MEMORANDUM

SUBJECT: Request for Certificate of Occupancy
Diver Down Underwater Services
385 Presumpscot Street (lot 420-A-007)

On February 12, 1998 I reviewed the site for compliance with the conditions of approval dated 10-3-97; my comments are:

SITE PLAN

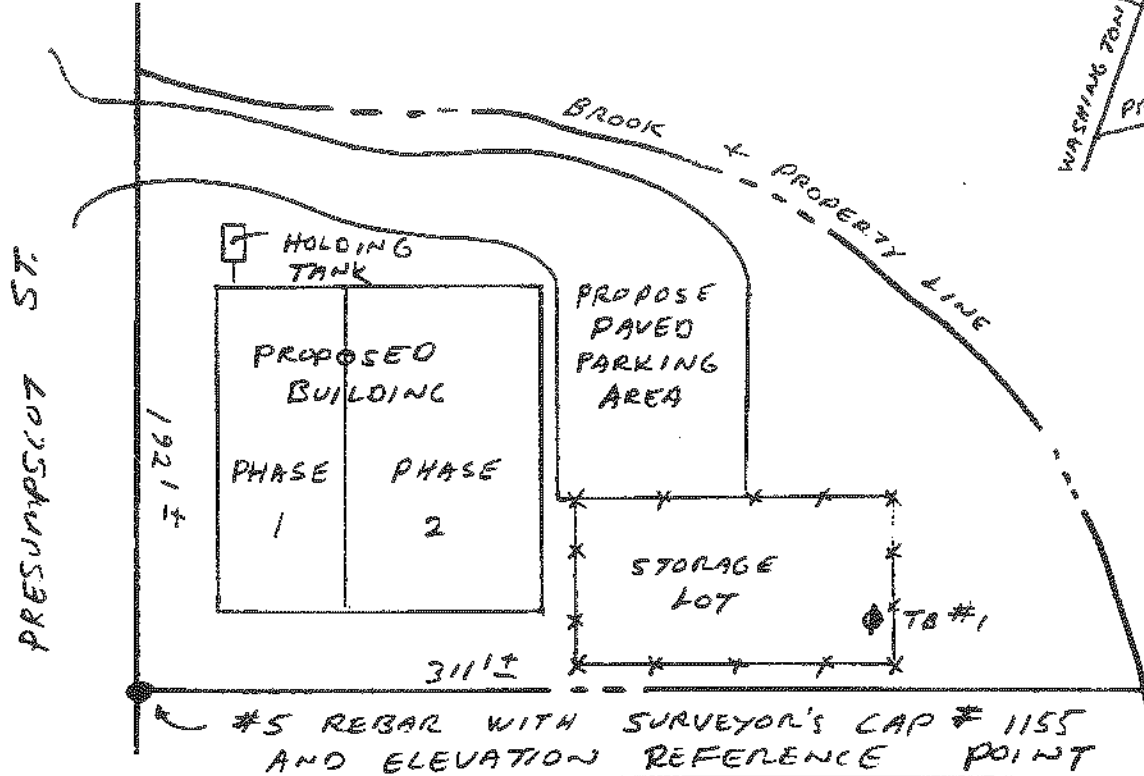
1. Final site is incomplete including the detention basin system and the curb work within Presumpscot Street. Some of the work does not conform to the site plan. A spring time review of the site work will be necessary. All site work shall be completed by June 31, 1998.
2. Erosion control measures in place are improperly installed, inadequate and in noncompliance with the approval.
3. The street address number needs to be placed on the house.

It is my opinion that when items 2 and 3 are completed a **temporary Certificate of Occupancy could be issued** assuming Code Enforcement has no outstanding issues. The applicant **must** contact the DRC for details of the requirements to conform with item 2 above.
